**RE: Response to Request for Information for SSD 8588  
Eastern Creek Business Hub (Lot 2)**

Ethos Urban has prepared this letter on behalf of Frasers Property Australia in response to your letter dated 7 December 2017, and the associated submissions received during the exhibition period of SSD 8588 and SSD 5175 MOD 3, relating to Lot 2 of the Eastern Creek Business Hub development.

PROPOSED STAGE 1 PLAN 1 : 500

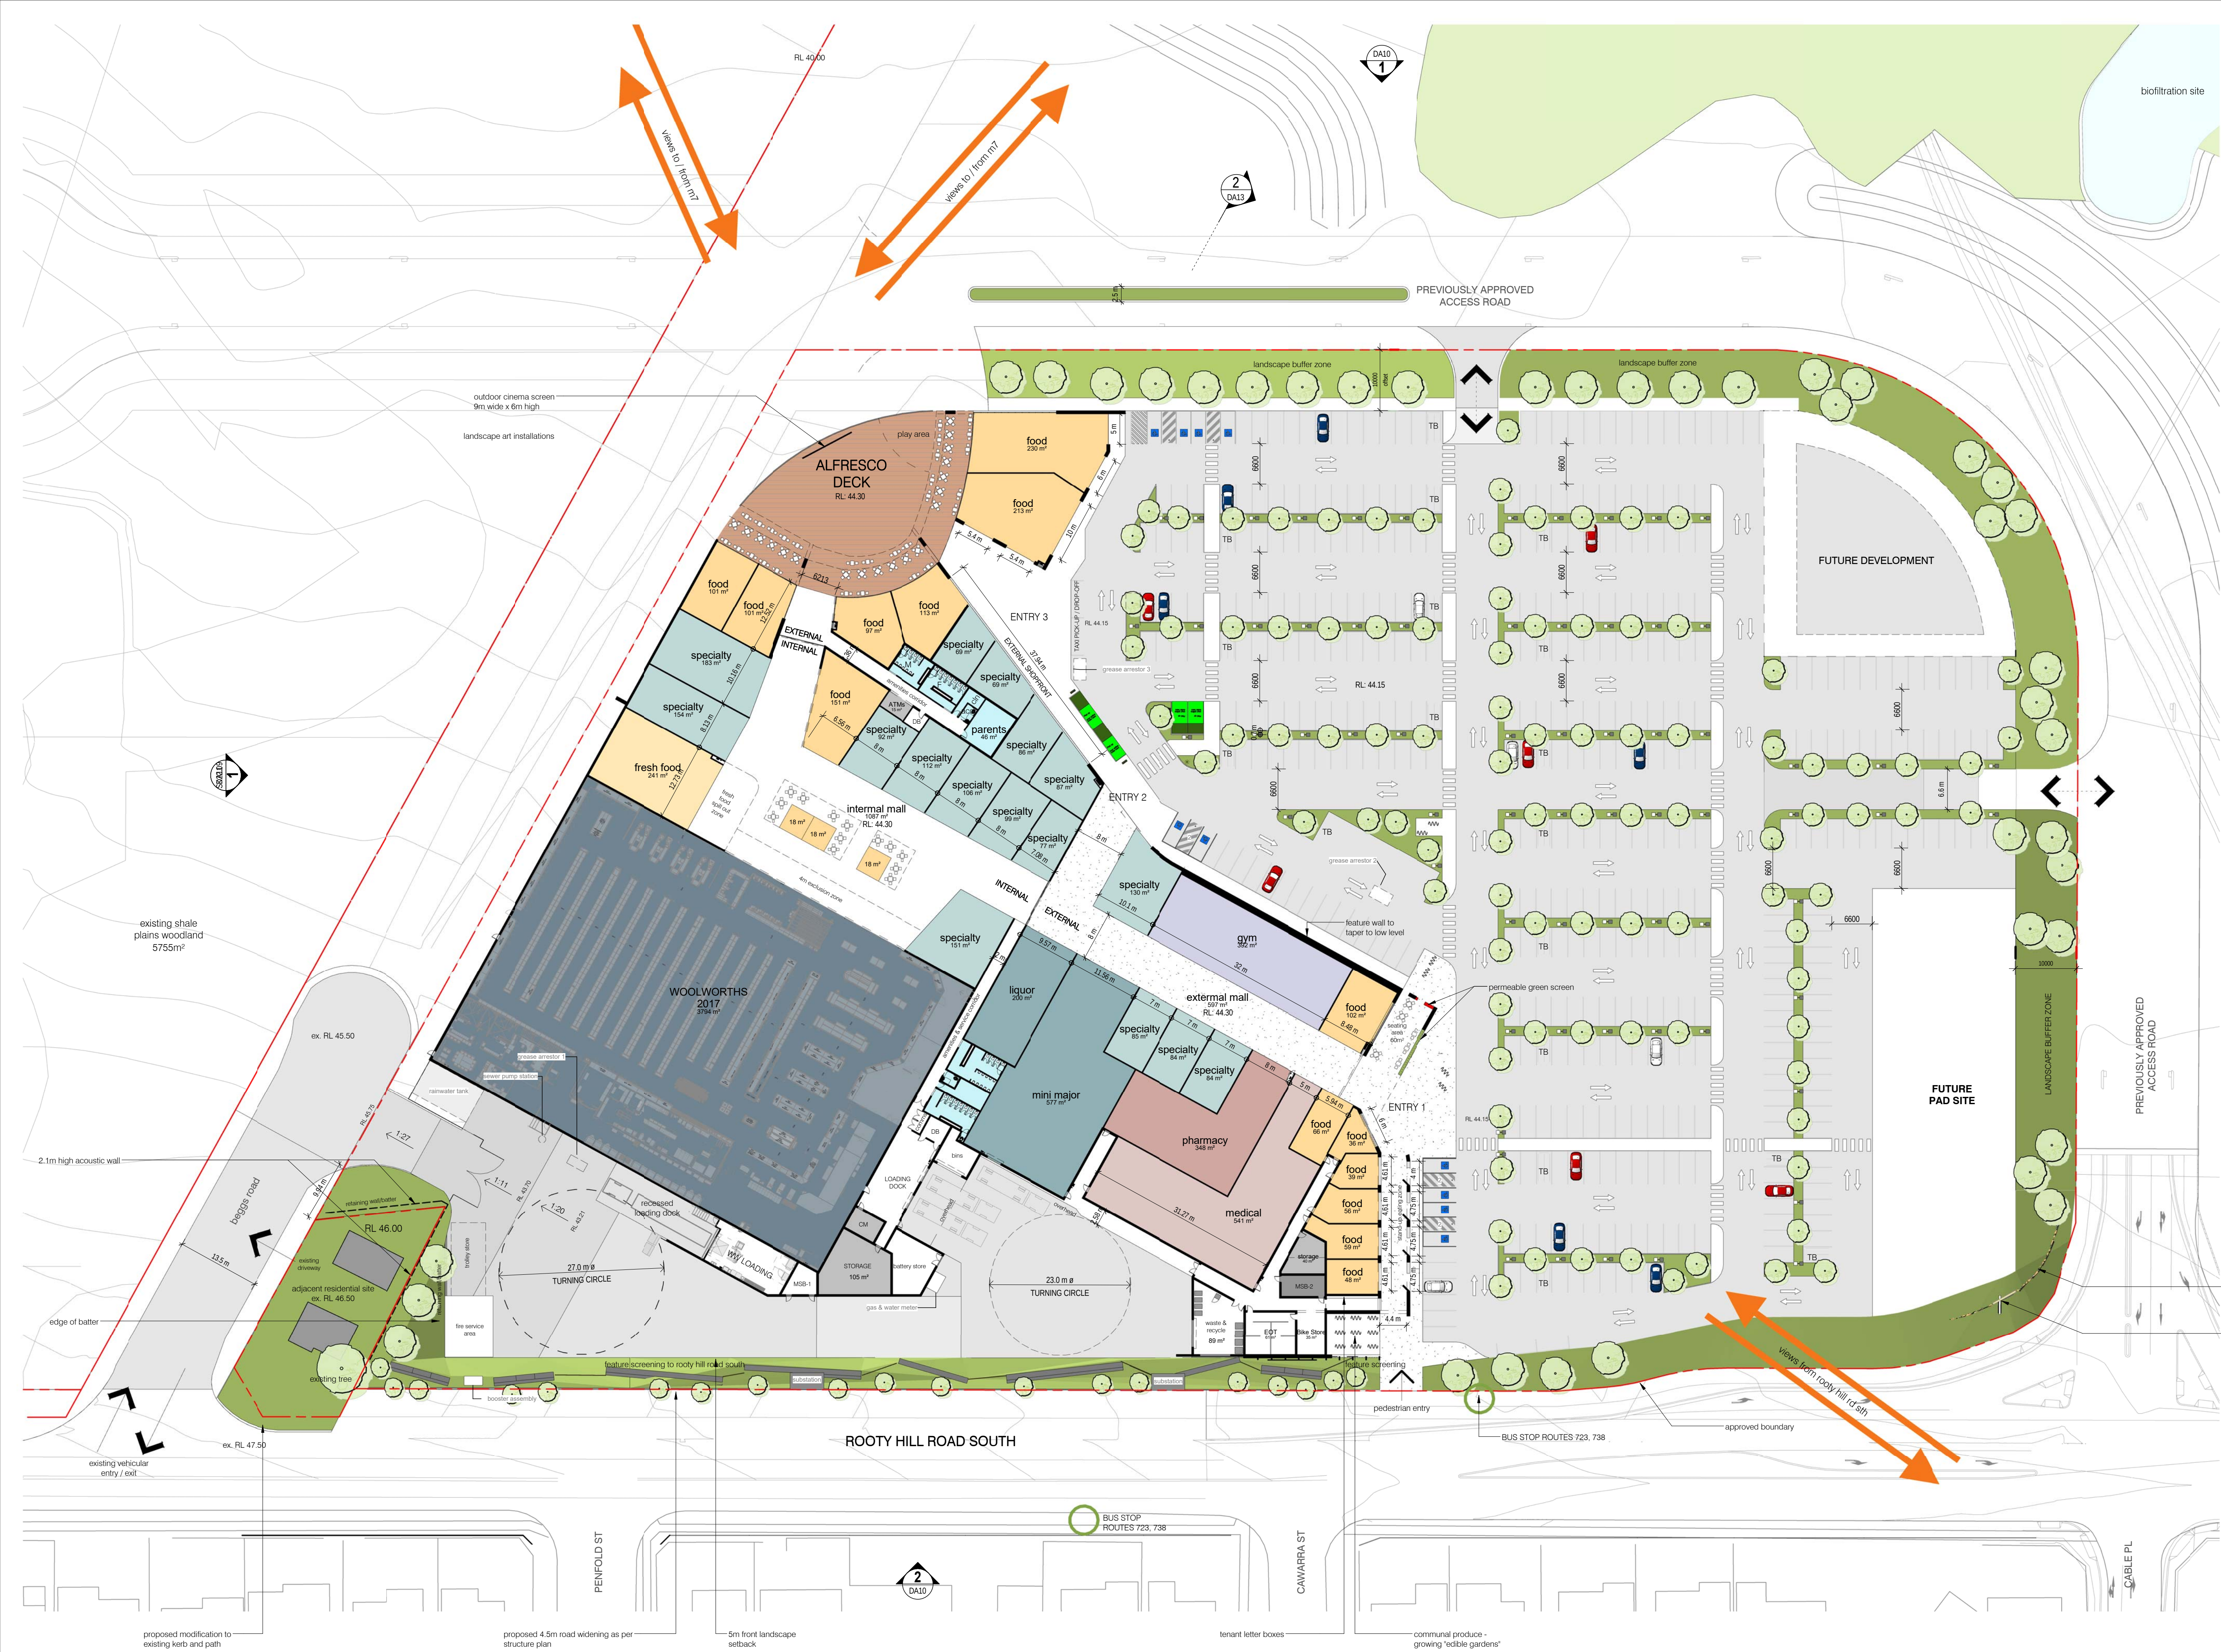
<b>Child Care Centre</b>	
<p>8. If the child care centre is no longer proposed, please provide updated plans including details on any future use of this portion of the site, which would be subject to separate approval.</p>	<p>The child care centre is no longer proposed in this location and updated plans are provided at <b>Attachment F</b>. At this stage the future use of this area has not been determined, however it may be used for a car wash facility subject to practicability. Therefore, the future use of this area will be subject to a future DA.</p>
<b>Outdoor Lighting</b>	
<p>9. Provide details of all other outdoor lighting in accordance with Condition B19 of the Concept Plan Approval, with particular regard to the car park and loading areas and an assessment of potential light spill impacts to neighbouring residential areas.</p>	<p>Additional details on the proposed outdoor lighting for the site is provided at <b>Attachment G</b>. This includes a product information sheet for the proposed lighting, a Lux Plot Plan and an Obtrusive Light Compliance Report. This information confirms that the proposed lighting scheme complies with the applicable Australian Standards and maximum illumination levels.</p>

STAGE 1 - SCREEN WALL PLAN 1 : 200

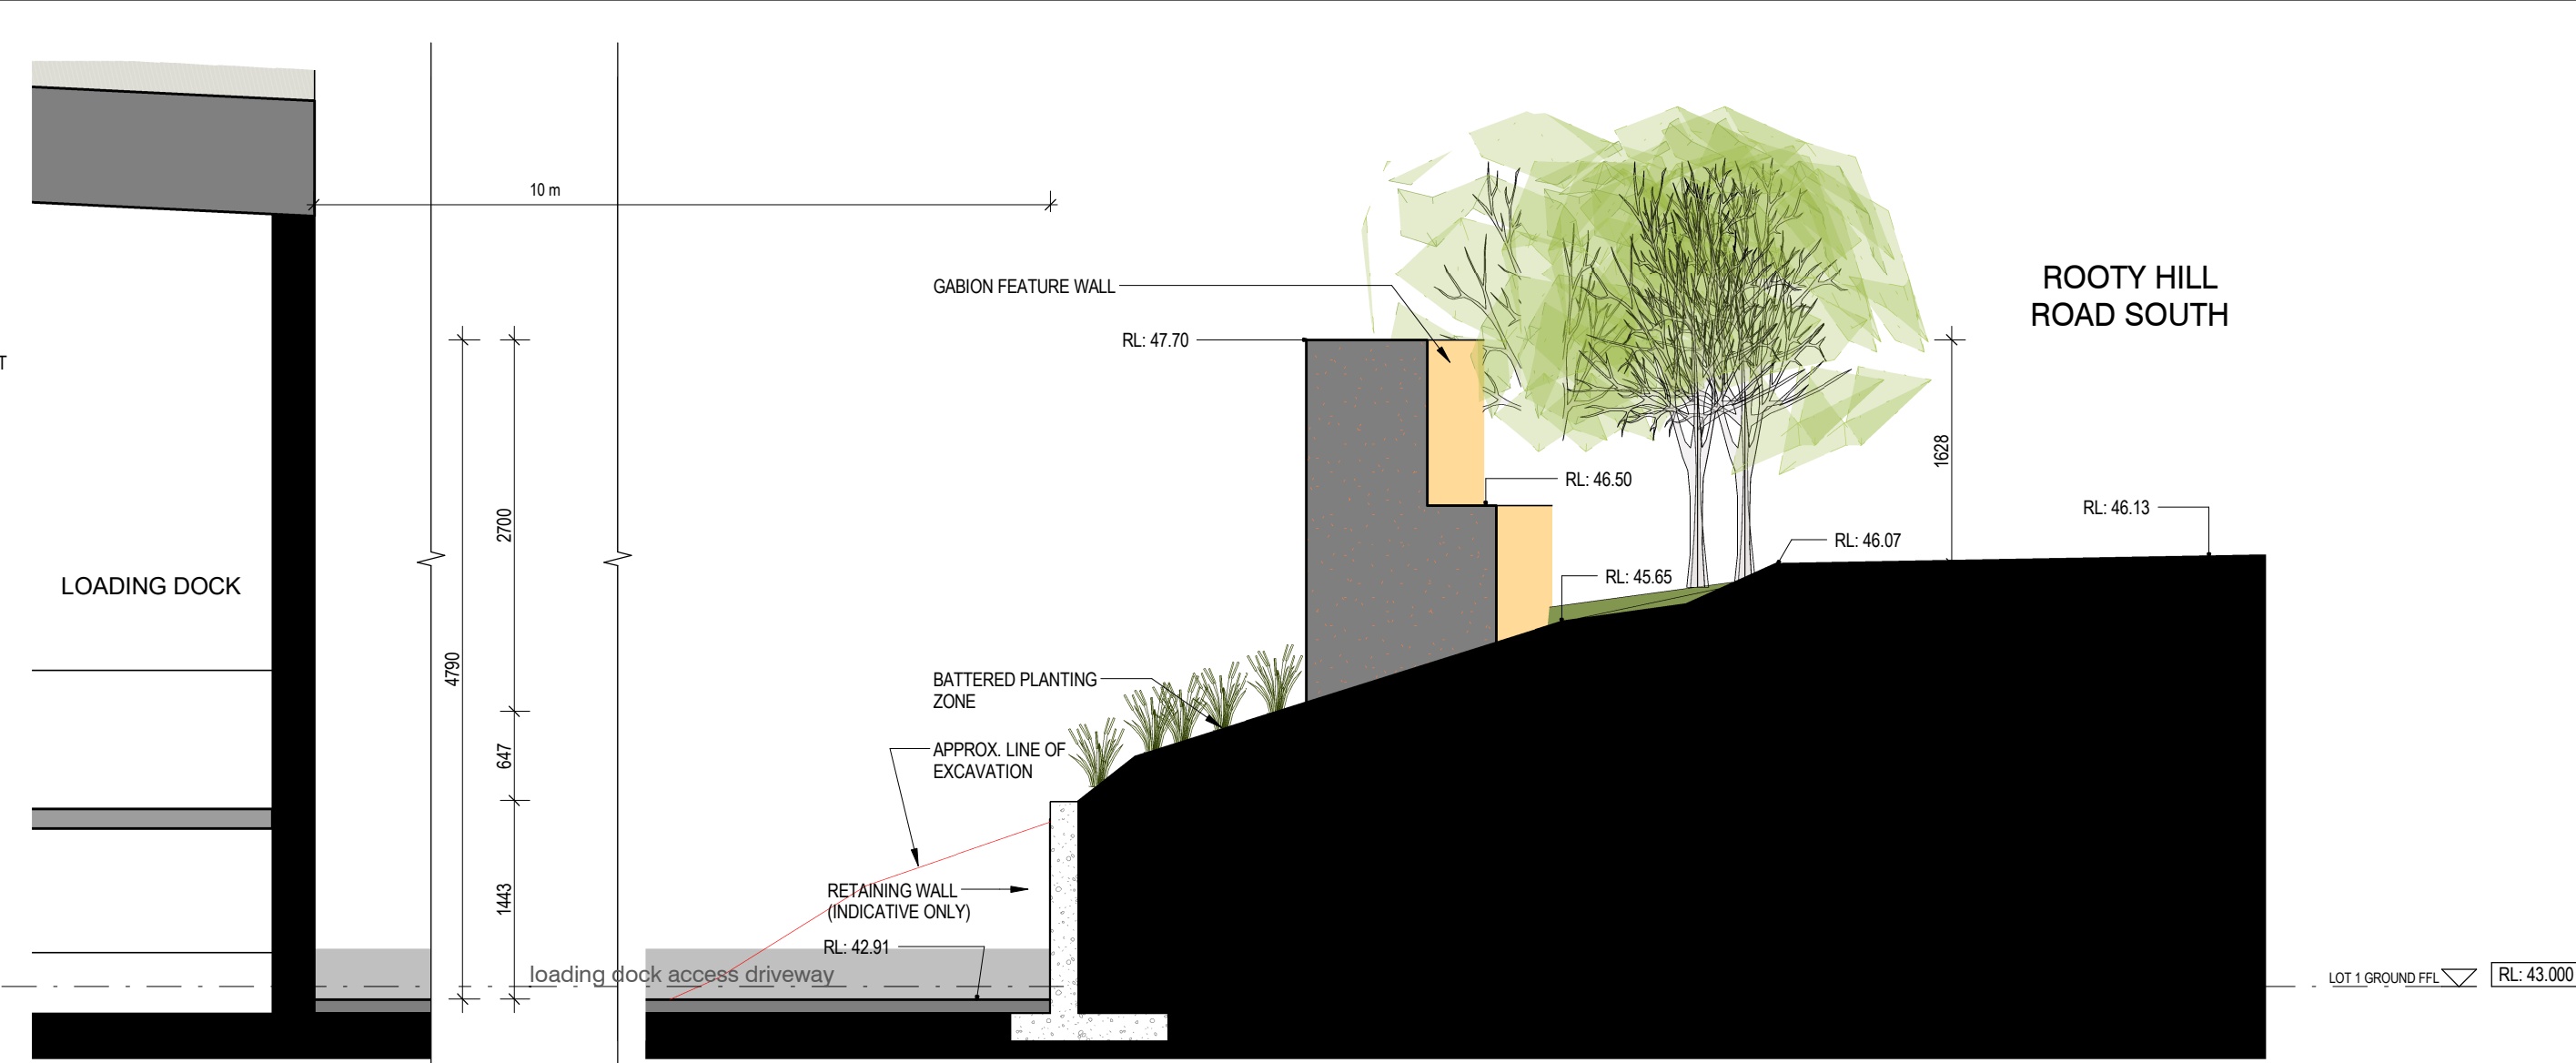
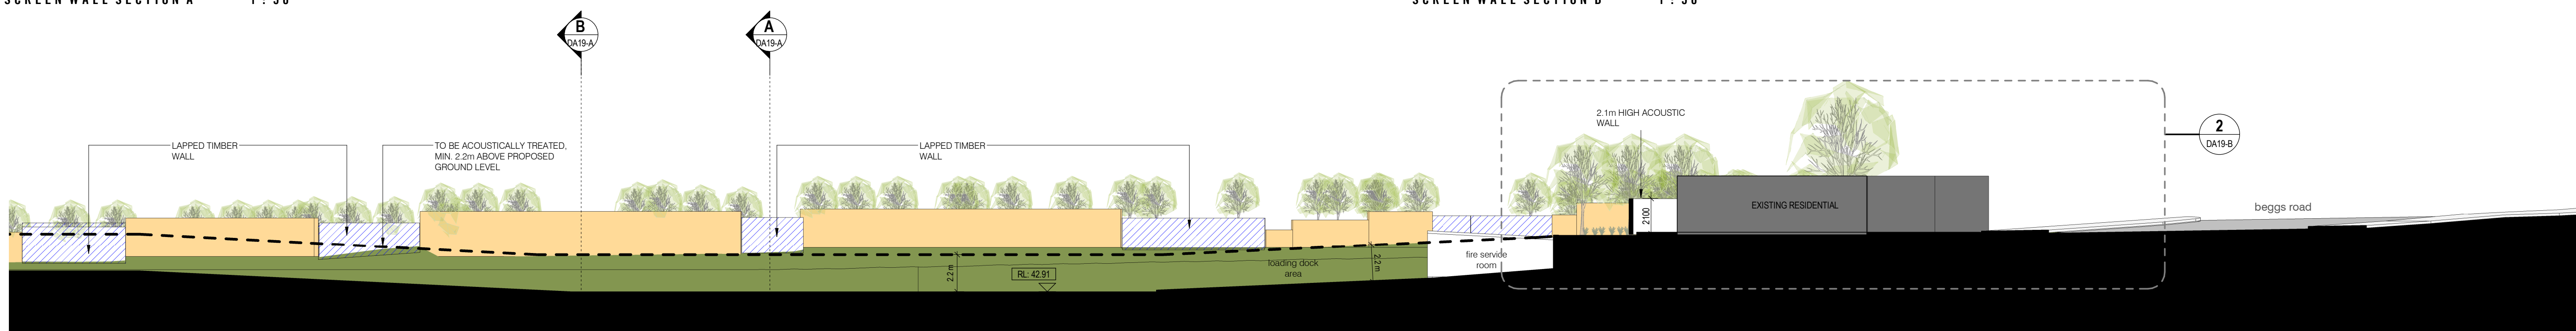
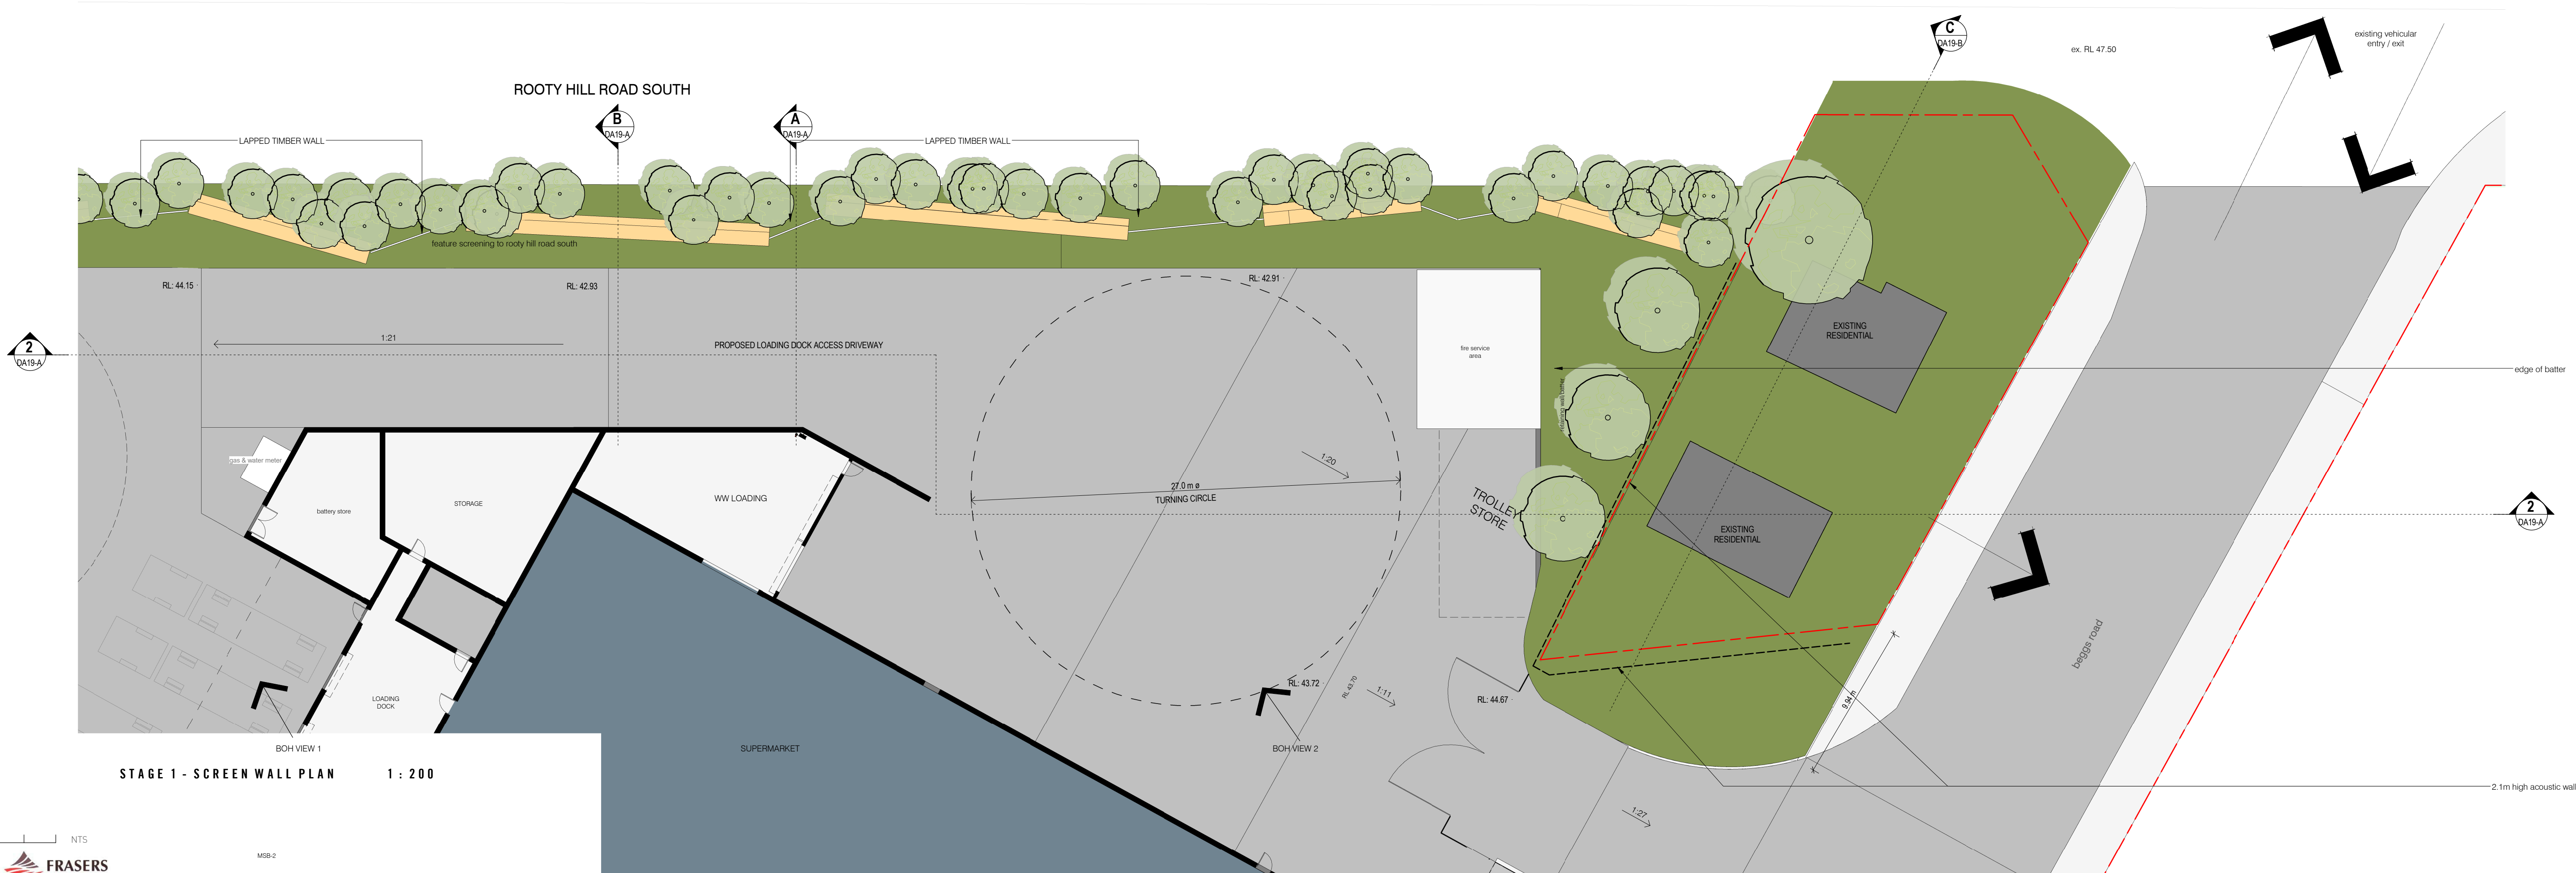
DPE Comment	Response
<b>Schedule 1 – Key Issues</b>	
<b>Visual Impact/Streetscape</b>	
<p>1. The following additional information has been requested:</p> <ul style="list-style-type: none"> <li>• Details of the location, type, material and finishes of the proposed acoustic wall and landscape treatment along RHRS.</li> <li>• Details of the materials and finishes for the shopping centre building.</li> <li>• Images at key locations showing building and material components and finishes and supported by an architectural design statement.</li> <li>• Additional aerial 3D perspectives showing the interface along RHRS, including the loading dock and the acoustic wall and landscape setback.</li> </ul>	<p>I2C has prepared Materials and Finishes Package (refer to <b>Attachment A</b>) that provides additional details of the location, type, materials and finishes of the proposed wall along Rooty Hill Road South and the retail centre building. This is accompanied by additional aerial perspectives (<b>Attachment B</b>) showing the interface along Rooty Hill Road South and an Architectural Design Statement (<b>Attachment C</b>) outlining the rationale behind the proposed building materials, lighting and screening.</p>

<p>3. Provide additional information to demonstrate that the effectiveness of the acoustic wall to mitigate noise impacts to the residential properties along RHRS, particularly given the distance and change in levels to the loading area.</p>	<p>Section 6.3 of the Updated Acoustic Report (<b>Attachment D</b>) provides an assessment of the ability of the proposed screening along the western boundary of the site to protect the acoustic amenity of residential properties on the opposite side of RHRS. The report notes that a 2.2m screen constructed from a solid material is required along the north western section of the site boundary to mitigate potential acoustic impacts of the loading dock. Acoustic Logic has reviewed the proposed masonry/lapped and capped timber design of the screen and confirm that this will be acoustically acceptable.</p>
<p>4. Provide the details of the location, height and materiality of any acoustic screen between the loading area and the adjoining properties fronting Beggs Road to ensure a satisfactory acoustic and amenity outcome for the adjoining properties.</p>	<p>Additional details of the proposed screening are provided on the Section Plans at <b>Attachment H</b> and within the Updated Acoustic Report at <b>Attachment D</b>. The proposed screen to the loading dock will include a 2.1m high, precast concrete retaining wall with landscaping. The acoustic report notes that whilst an acoustic wall is not required at this location to meet the relevant noise criteria (due to the barrier effect provided by the change in ground level), the proposed screen will further reduce noise levels and protect the acoustic amenity of the neighbours to the north.</p>
